CITY OF ALBUQUERQUE

June 9, 2016

RE: **HLP Endodontics**
10429 Lagrima Del Oro NE
Requested for Permanent C. O. – Not Accepted
Engineers Stamp Date 6/29/15 (F21D063)
Certification dated: 6-2-16

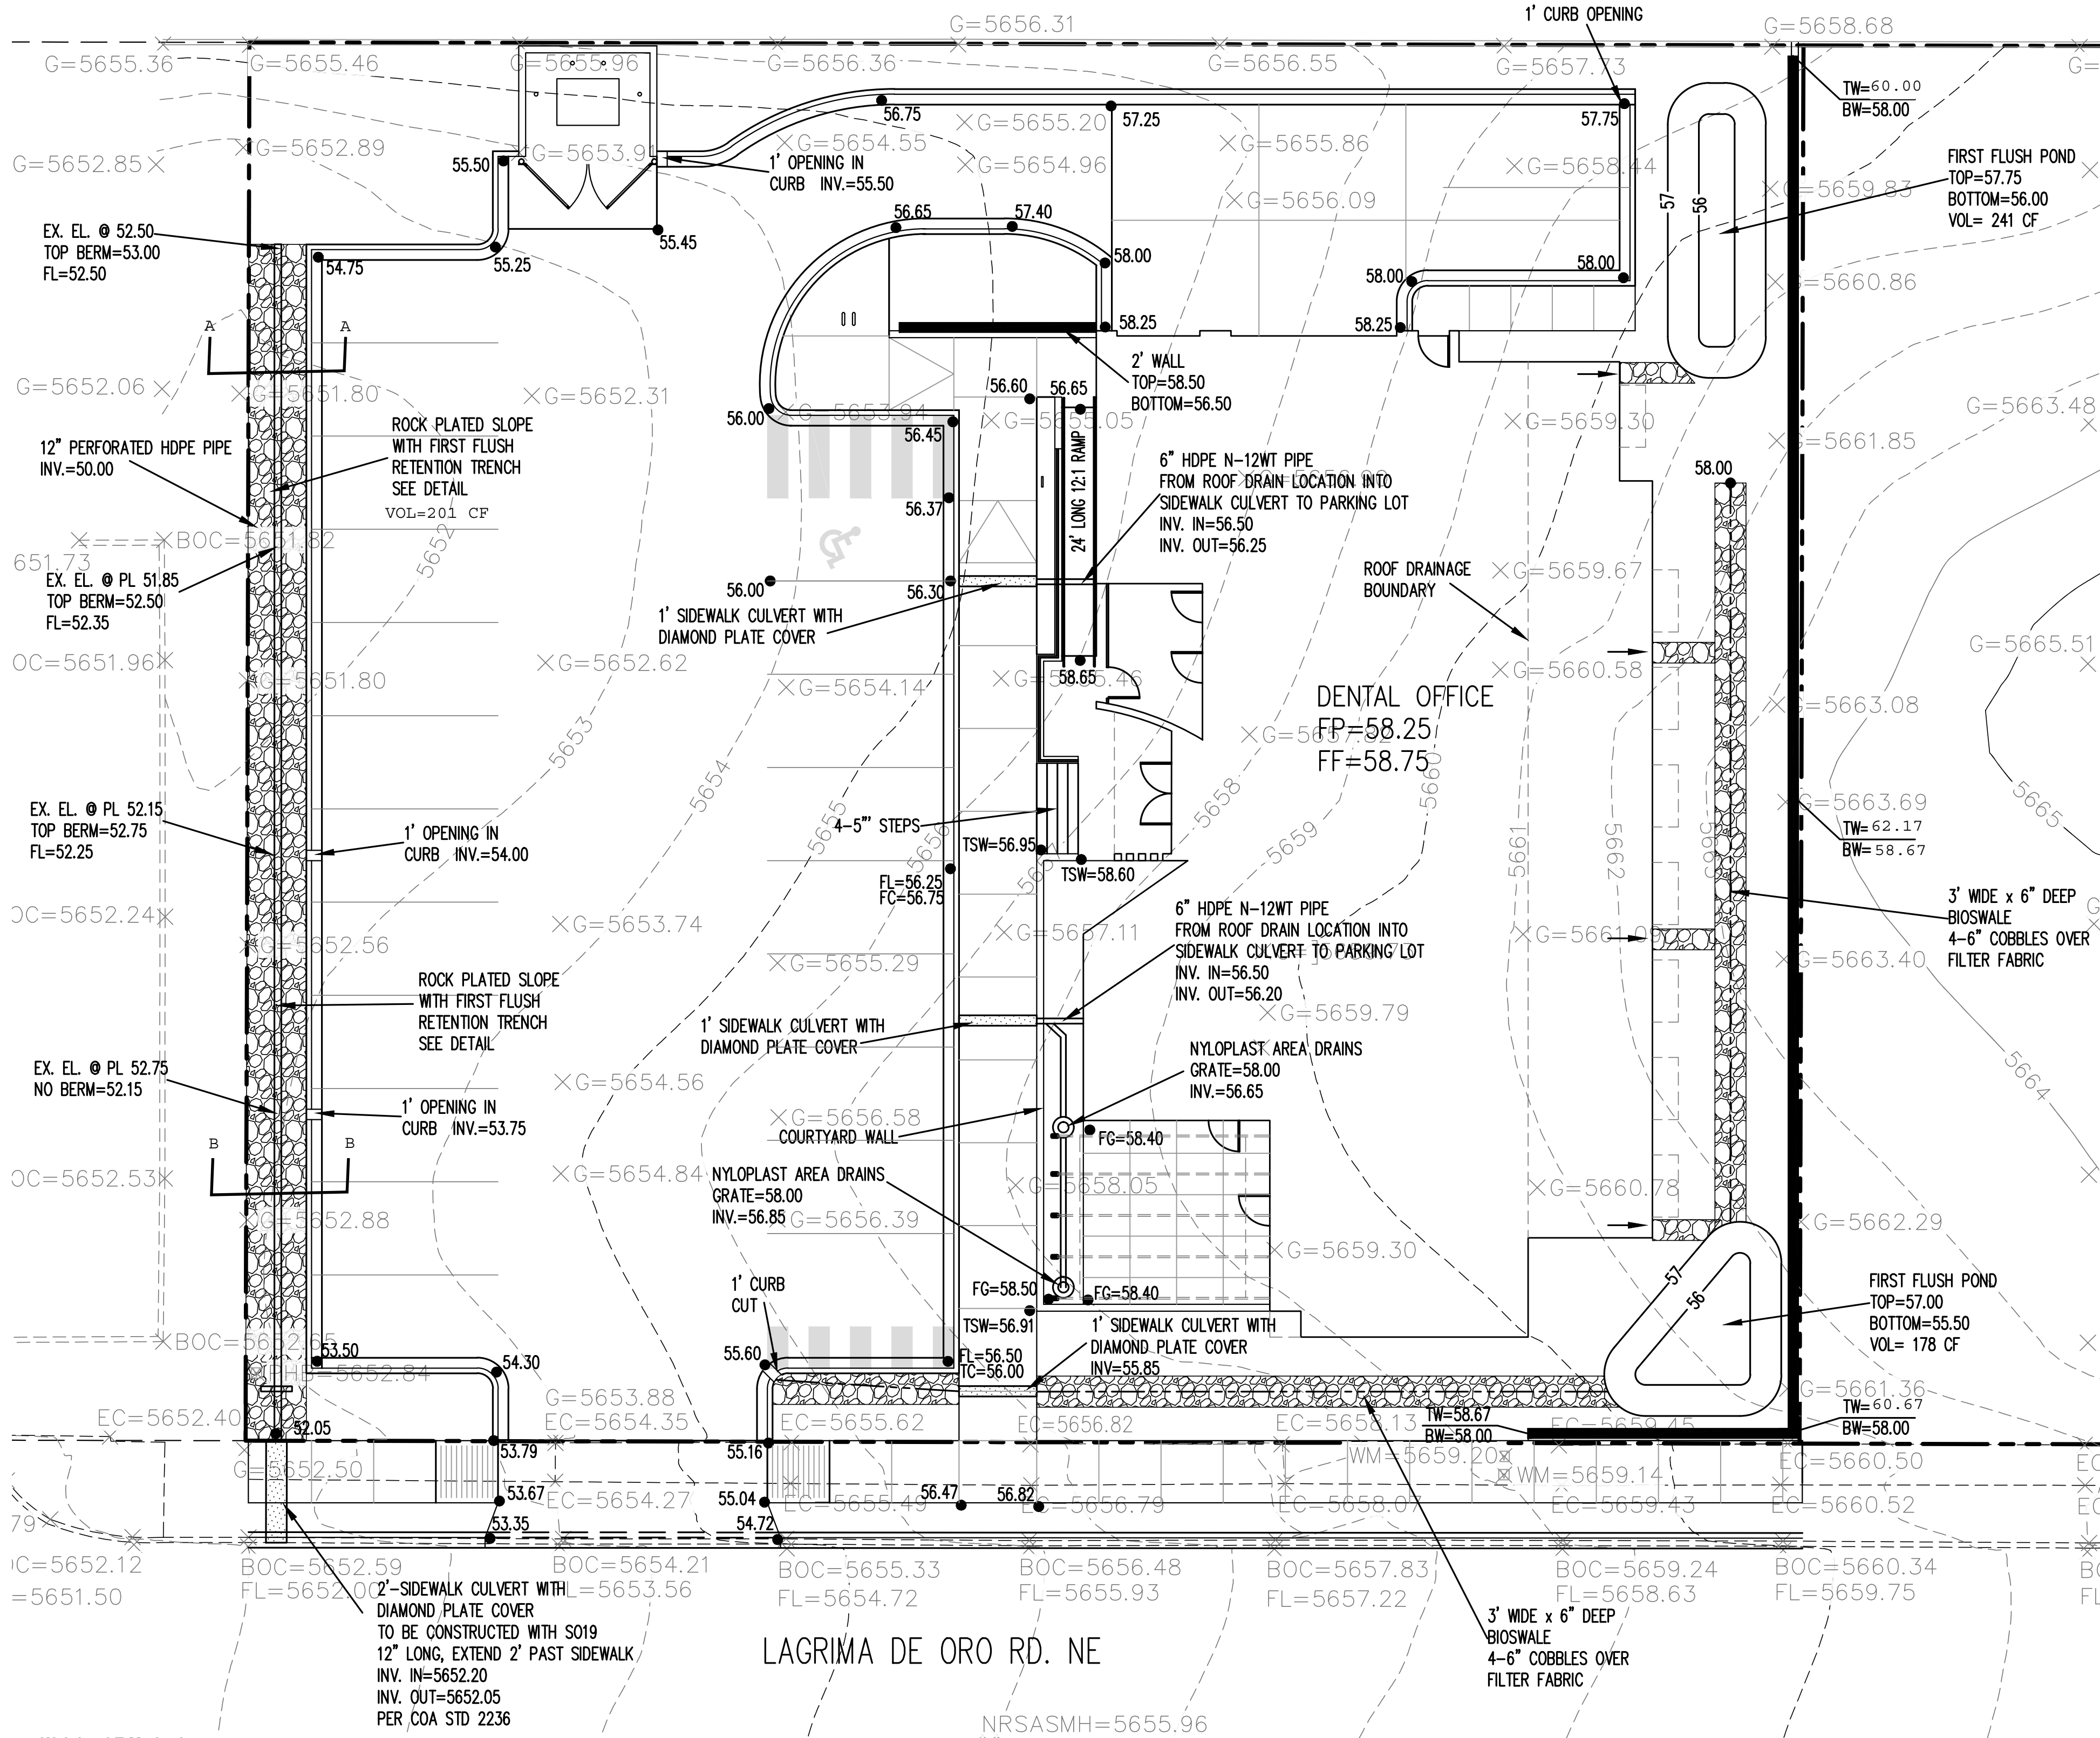
- Both 1'-0" curb openings on the north end are missing.
- There is a transformer where the pond at the NE corner was approved. New drainage flows are not as-built on the drawing.
- Only a portion of the rock plated slope w/ retention trench is constructed on the west side. Per the superintendent on site, the portion not constructed is being changed to a retaining wall. This has not been as-built on the drawings.
- The SO-19 sidewalk culvert should be poured monolithic. Culvert should be 2'-0" however it only measures 1'-4".
